From: Fiona Fitzgerald <Fiona.Fitzgerald@arun.gov.uk>
Sent: 19 November 2020 20:52
To: Planning.Responses <Planning.Responses@arun.gov.uk>; Chris McConnell [REDACTED]
Cc: Raymond Cole <Raymond.Cole@arun.gov.uk>
Subject: F/4/20/OUT

Further to our conversation last week, I have reviewed the documents submitted in F/4/20/OUT. My comments are below:

Figure 2: Indicative extent of acoustic barrier at Ford Industrial Estate

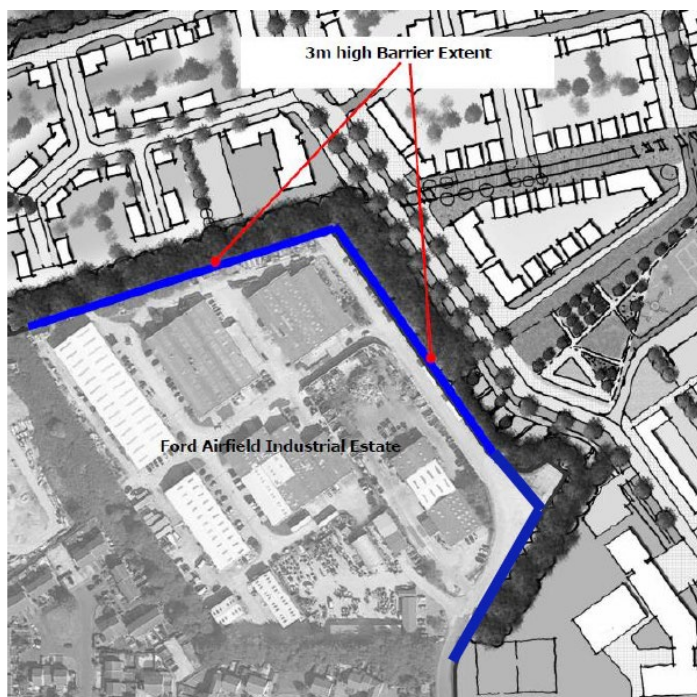
With regard to dwellings to the north of Ford Industrial Estate, Environmental Health remains of the opinion that a rating of +10dB, as it is considered to generate a significant adverse impact, is not acceptable, even with mitigation as described.

Figure 3: Potential noise sensitive areas

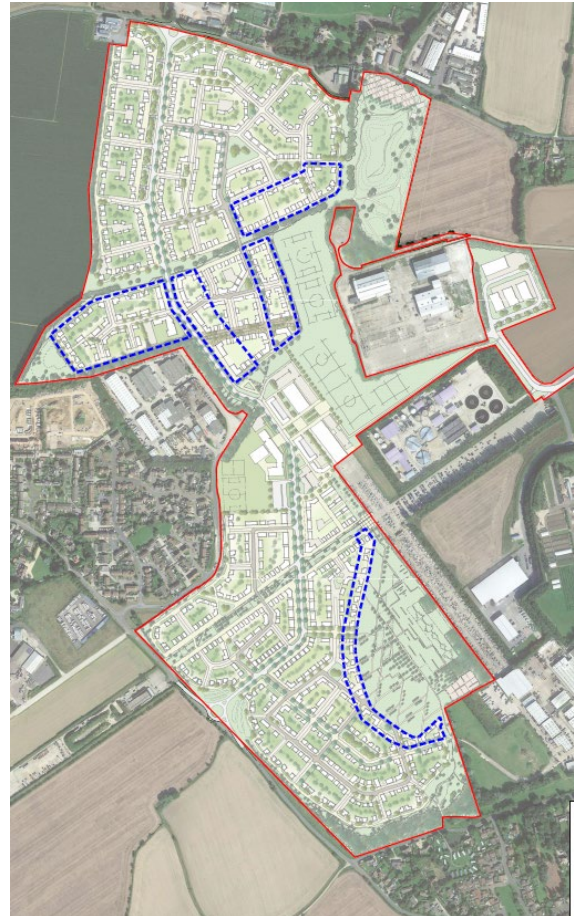
In terms of dwellings facing Yapton Road and Ford Lane there is no indication of how many dwellings would require the mitigation and to what extent and therefore it is not possible to make an adequate assessment of the likelihood of impact on amenity as it is not known how many of the dwellings will be affected.
